DELEGATED DECISION TO DETERMINE PLANNING APPLICATIONS

Reference No:	2023/62/91486/E
Site Address:	110, Spen Lane, Gomersal, Cleckheaton, BD19 4AA
Description:	Formation of parking area and entrance wall with associated alterations
Recommending Officer:	Nina Sayers

Officer Report

PROPOSED SITE PLAN 1:100

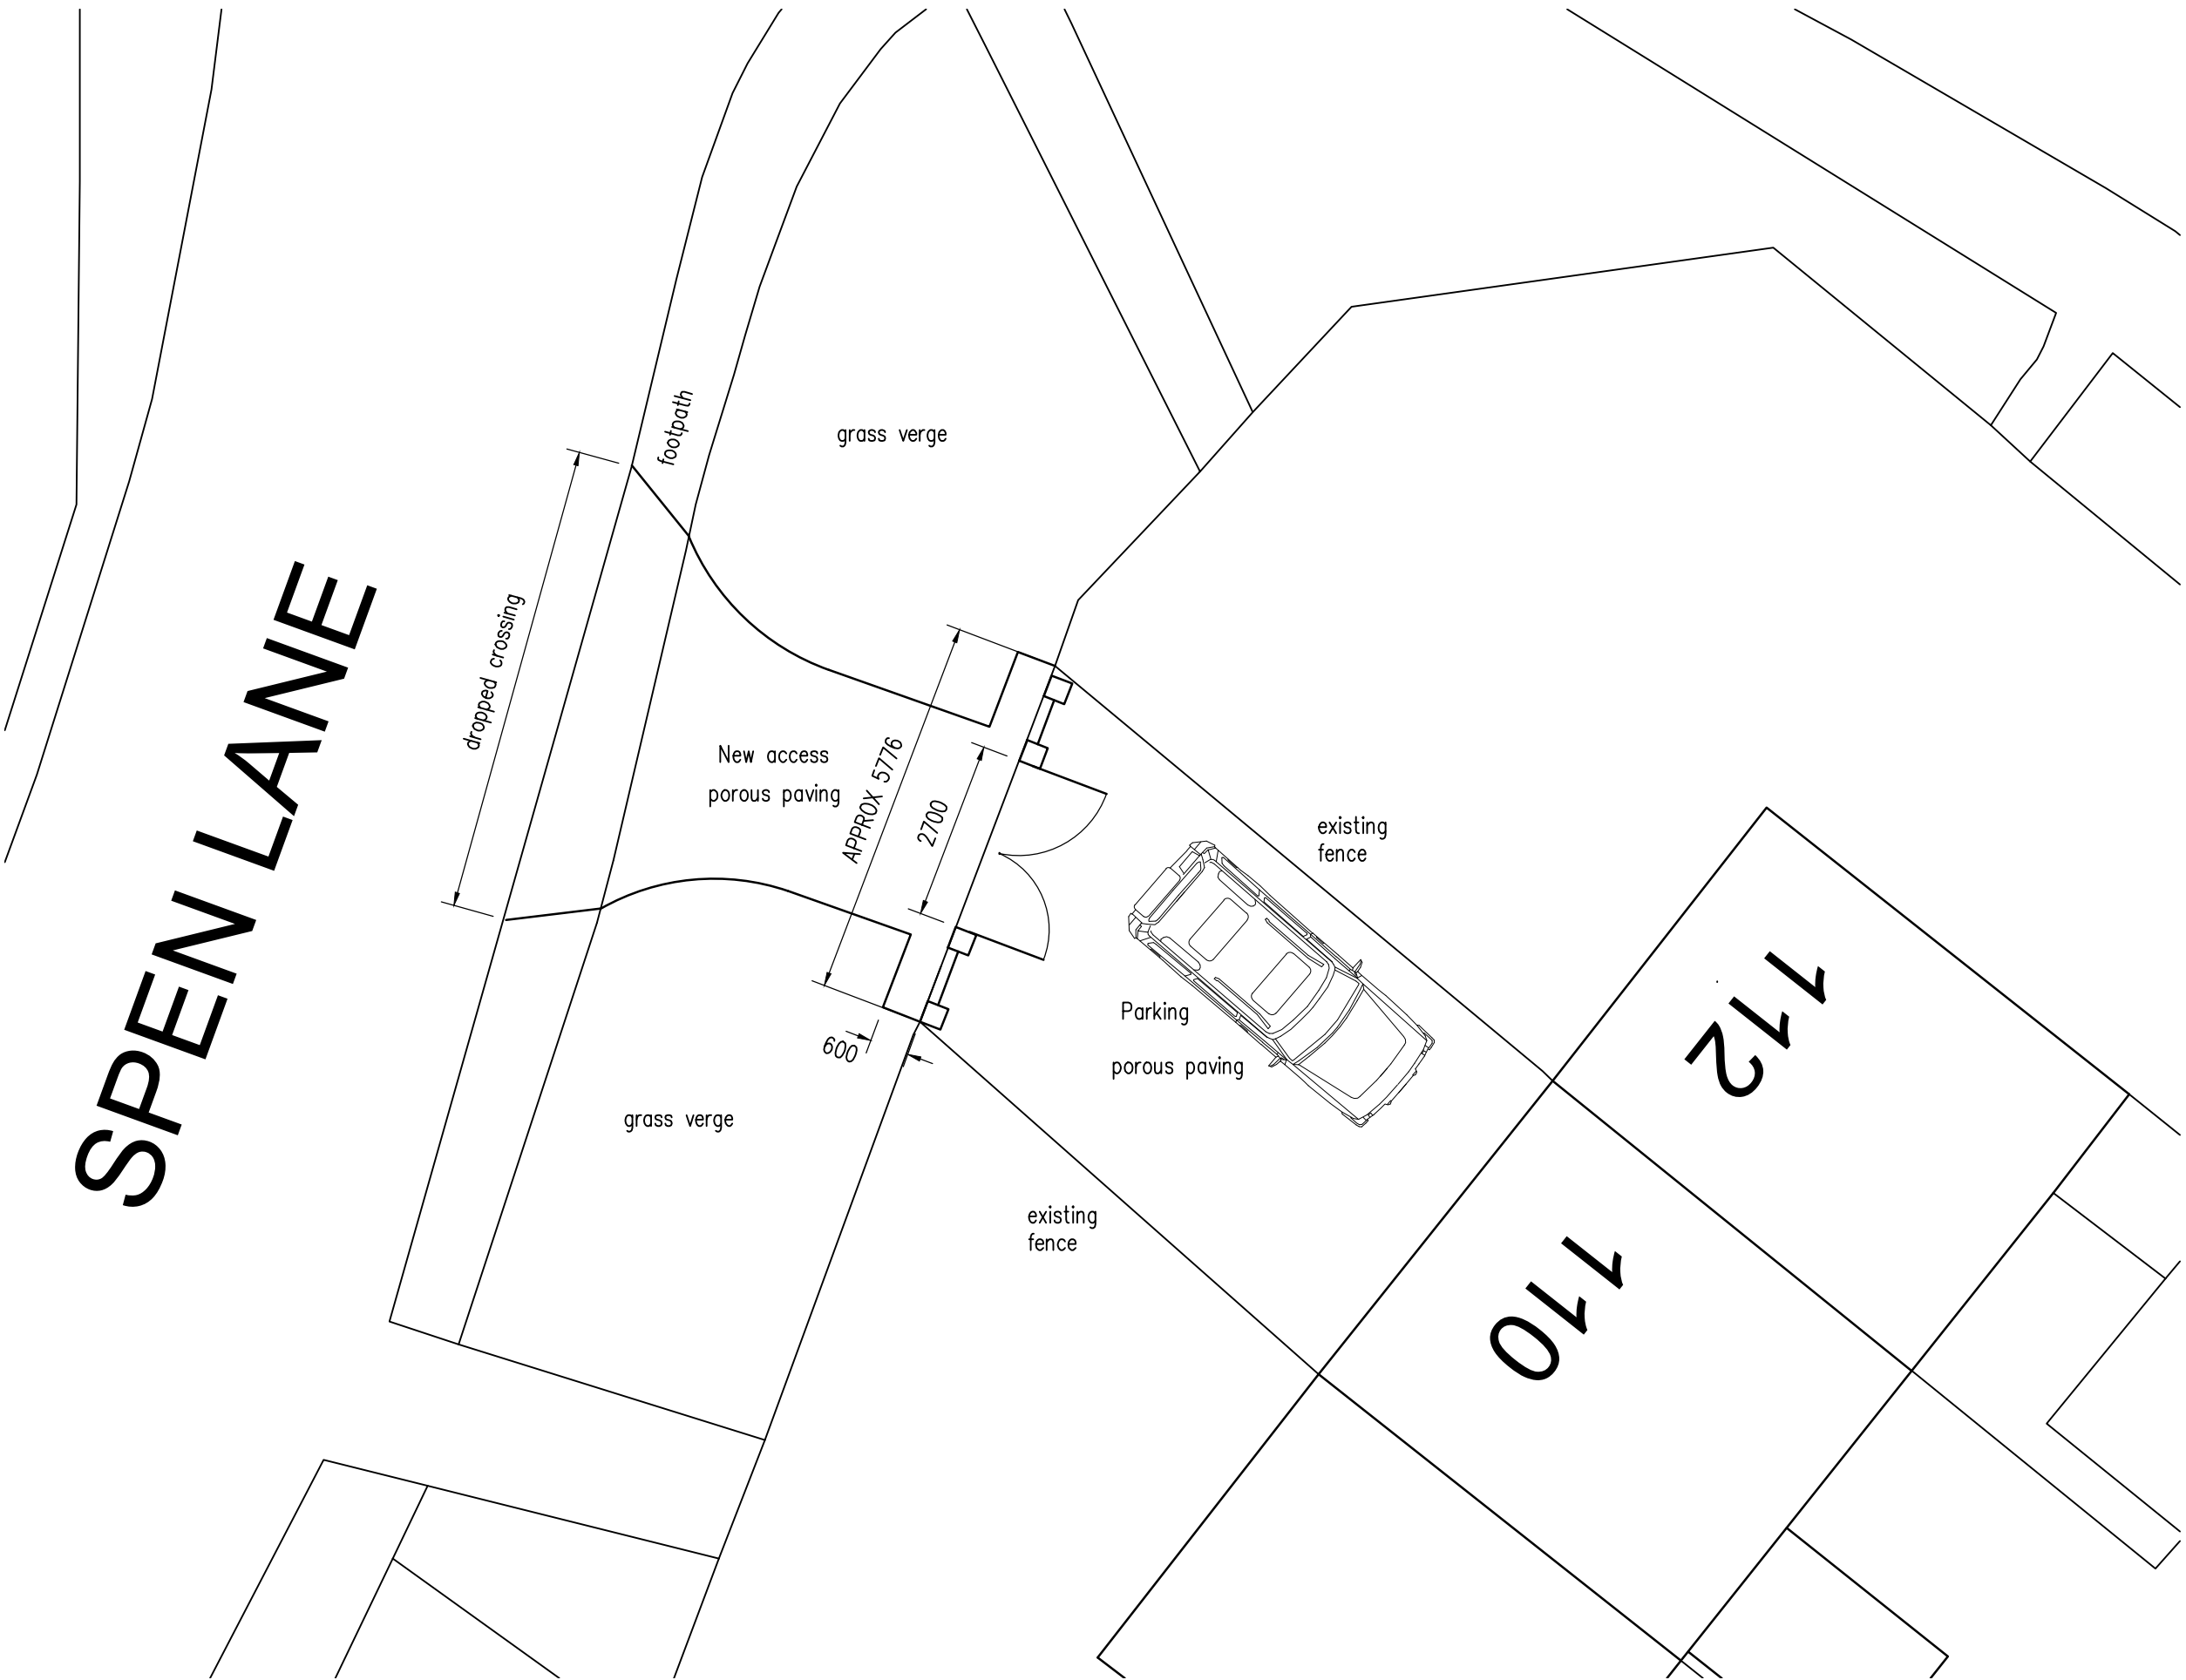
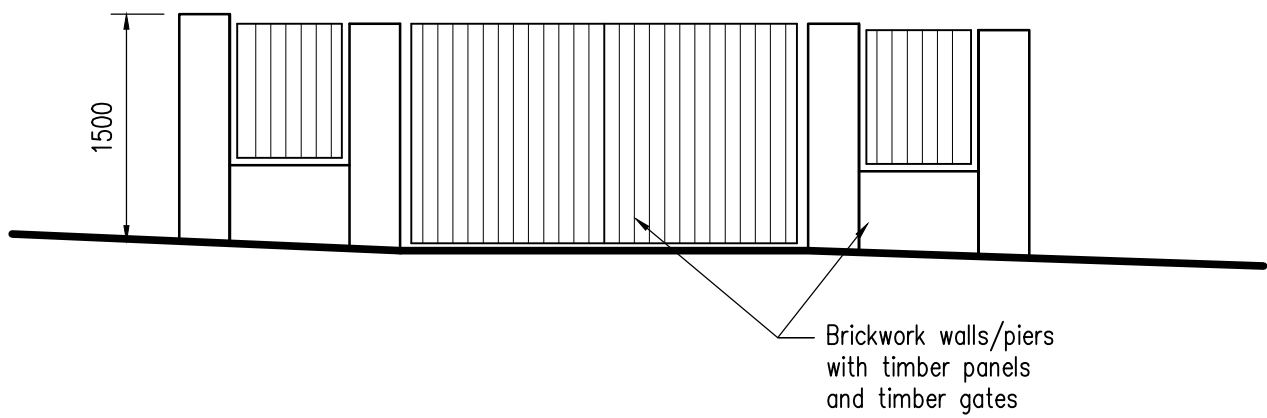
Officers had concerns regarding the significant amount of hardstanding proposed and therefore amended plans were sought and received which retained some soft landscaping to the front of 110 Spen Lane.

It is noted that additional hard standing would be introduced as part of the proposal, however this would be located between an existing domestic curtilage and the directly adjacent highway and would be to a relatively small area. It is noted that the amount of hardstanding has also been reduced following amended plans requested by officers. It is therefore considered that the proposal would not result in significant harm to the openness of the Green Belt. As such, the proposed scheme would not be considered inappropriate development in the Green Belt and the principle of development is considered acceptable.

The proposal would introduce additional hardstanding to the front of the property which would be visible from the highway. Paragraph 4.43 of the Kirklees House Extensions and Alterations SPD outlines that “careful consideration should be taken to retain as much of the garden boundary and soft landscaping as possible”. Officers initially raised concerns regarding the amount of hardstanding proposed as it dominated the front of the property, however this has been reduced to maintain some greenery to the side of the proposed access.

There would be no on-site turning space within the application site and due to the scale of the site this could not be provided. Therefore, vehicles would need to reverse onto the driveway from Spen Lane. Normally, for any new access onto a classified A road, it would be required that turning was provided within the site so vehicle could enter and exit in a forward gear. It is considered, on balance, that the proposed scheme would be considered acceptable as it would negate the need for residents to park on the highway in the vicinity of the application site and therefore there would be no significant additional highway concerns over and above the existing arrangements. It is also noted that the proposed arrangements are similar to that implemented at the adjacent property.

It would be conditioned that the proposed vehicle parking areas are surfaced in an appropriate, permeable material. A new vehicular crossing would need to be provided for the proposed driveway. A footnote would be added to any positive decision regarding the applicants' requirements to consult with Design Engineers.

PROPOSED ENTRANCE WALL/GATE ELEVATION 1:50

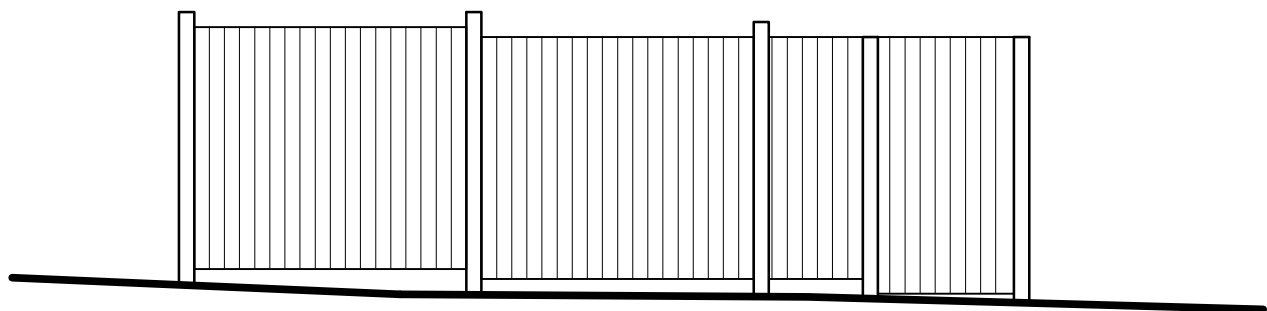
The proposed boundary treatment would be brickwork walls with timber panels and timber gates. The existing boundary treatment is timber, and it is noted that there is variety in the boundary treatment at the neighbouring properties. The proposal is therefore considered acceptable.
